CITY OF ALBUQUERQUE

May 10, 2019

Re: McDonalds - 8315 Montgomery Blvd NE
Grading and Drainage Plan
(Sheets C7.0 & C8.0) - Engineer's Stamp date 4/4/2019
(Sheets C8.1 – C8.3) - Engineer's Stamp date 5/14/2019
(F19D013A)

Based on the application received 5/14/2019 and the \$920 Payment in Lieu received 5/16/2019, the above referenced plan is approved by Hydrology for Building Permit.

GRADING PLAN

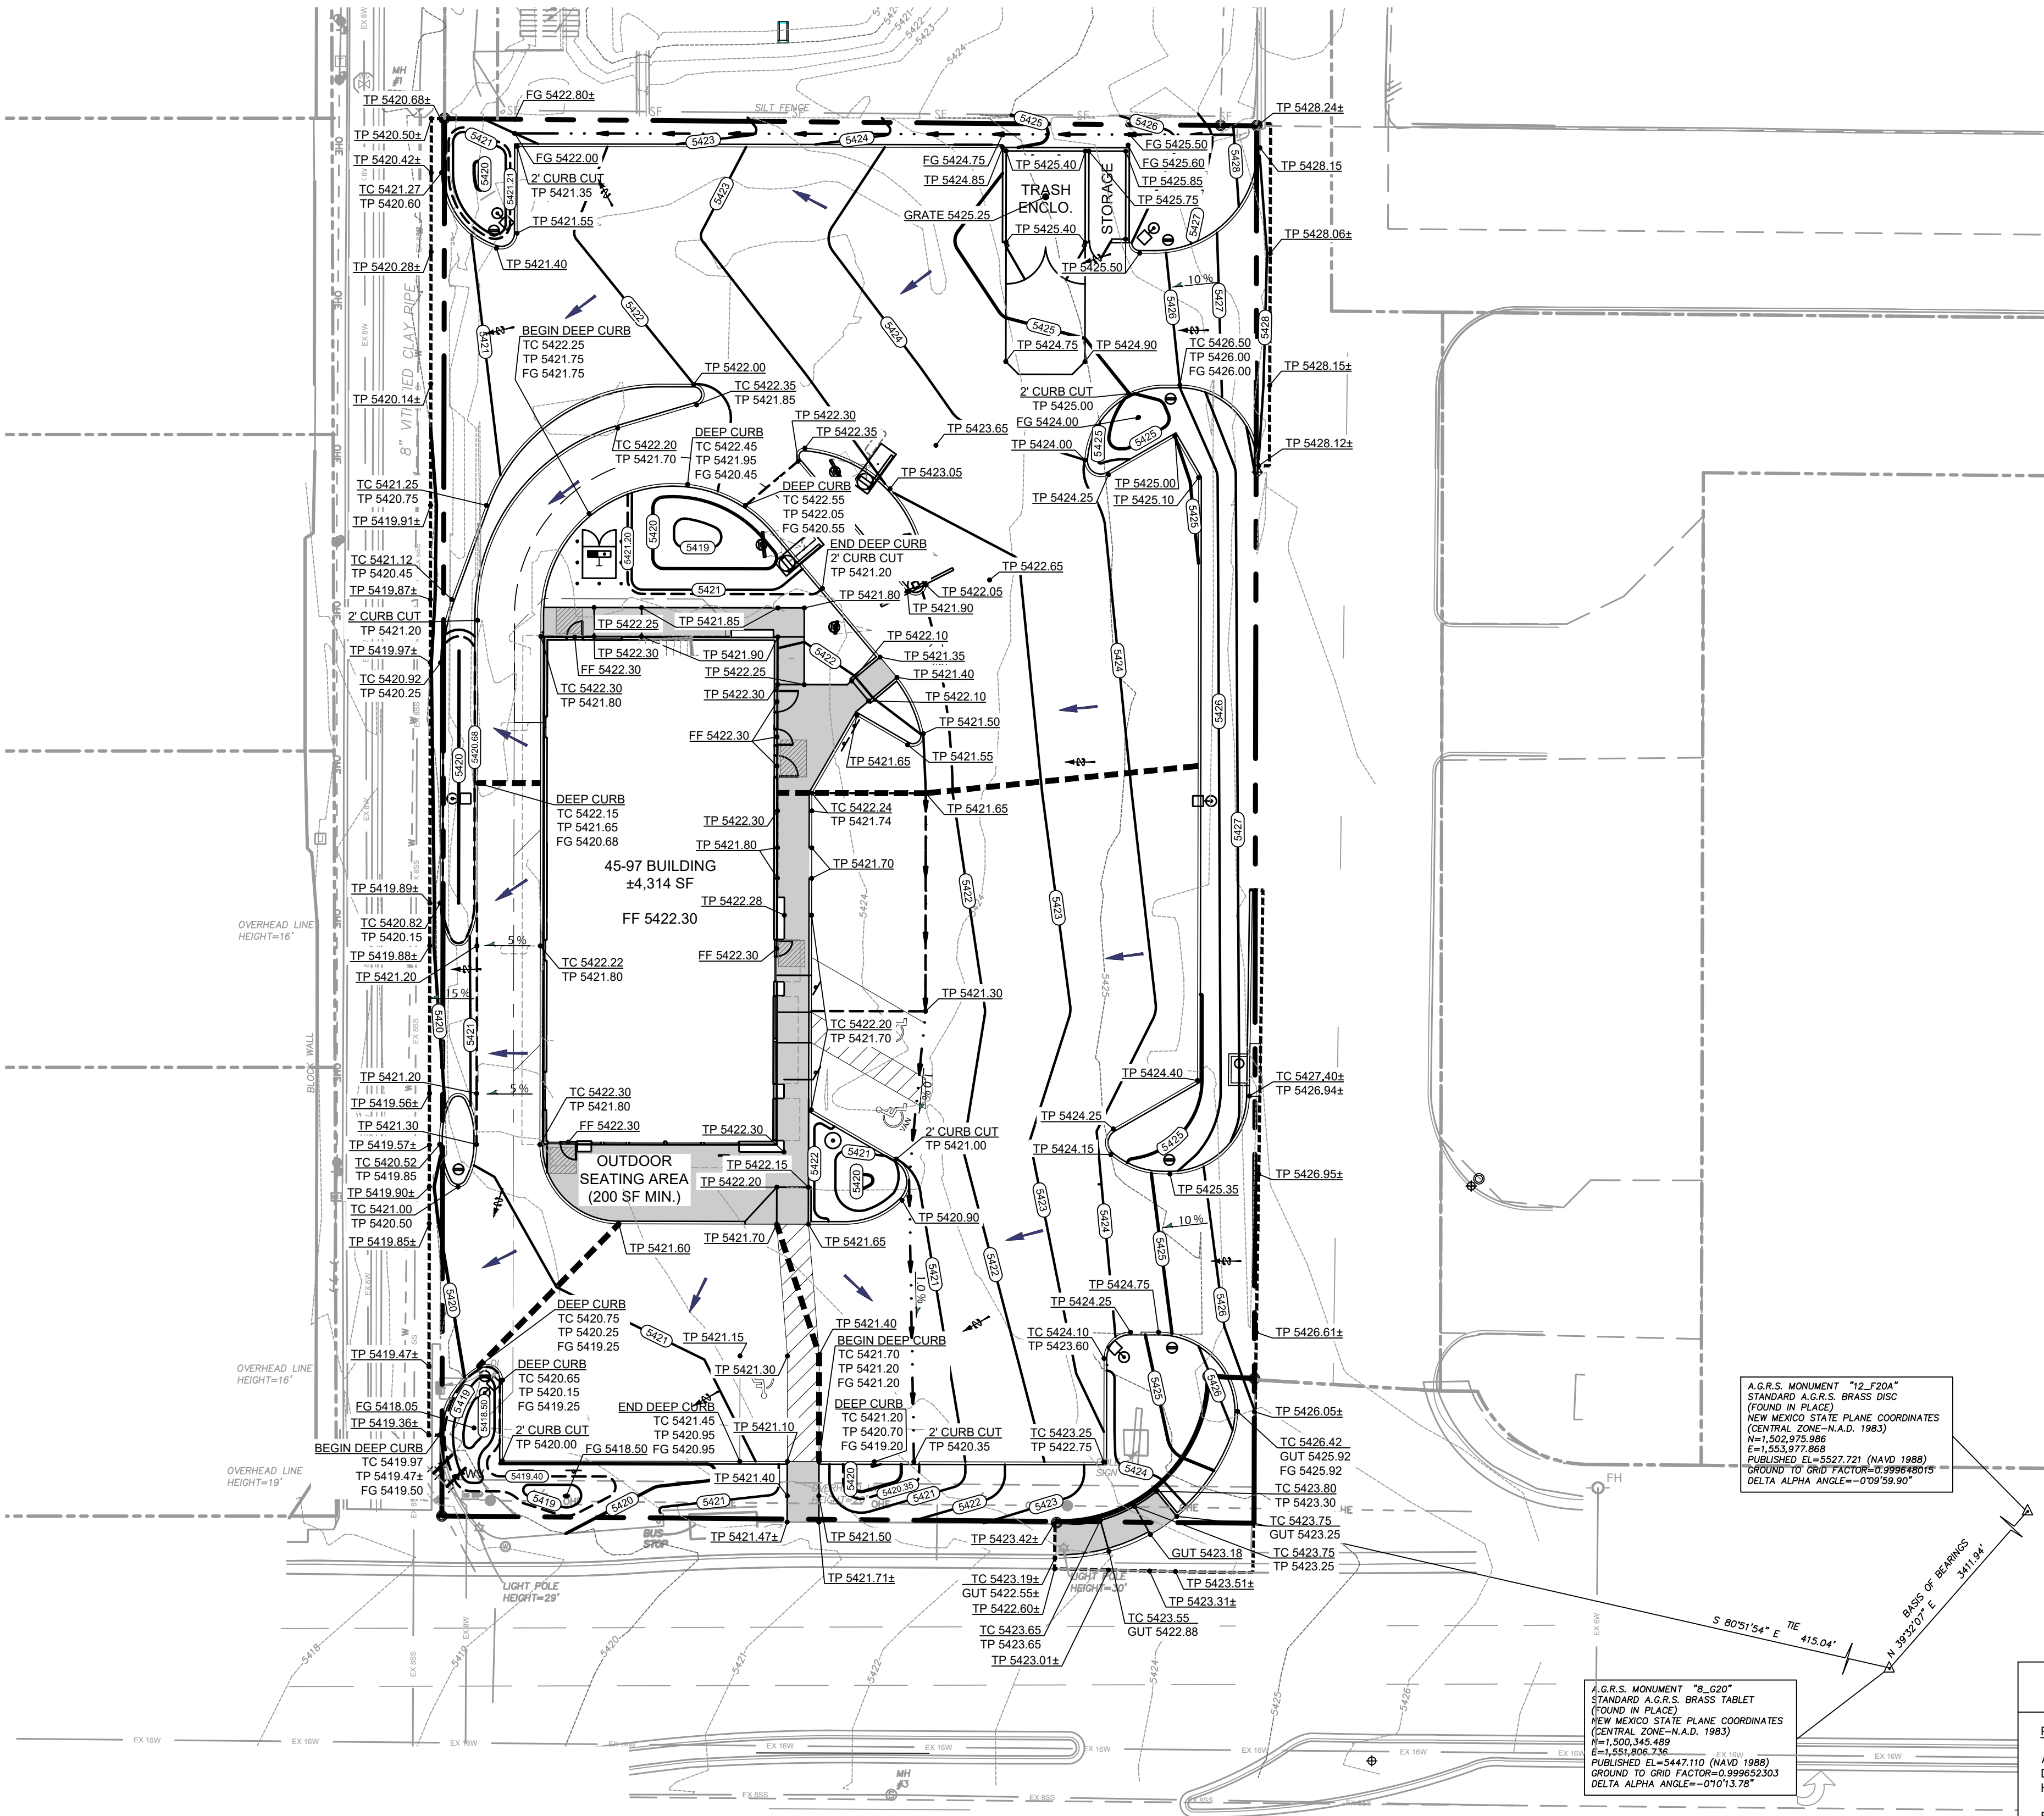
4. A Private Drainage Easement is required for the offsite storm drain on Tract A-1-E. Please provide a copy of the recorded easement that clearly indicates maintenance responsibilities and beneficiary. Also show the easement on the G&D Plan sheet C7.0 and label Tract A-1-E, Access A, and A-1-D and the other easements and utilities in the offsite area of construction north of this site.
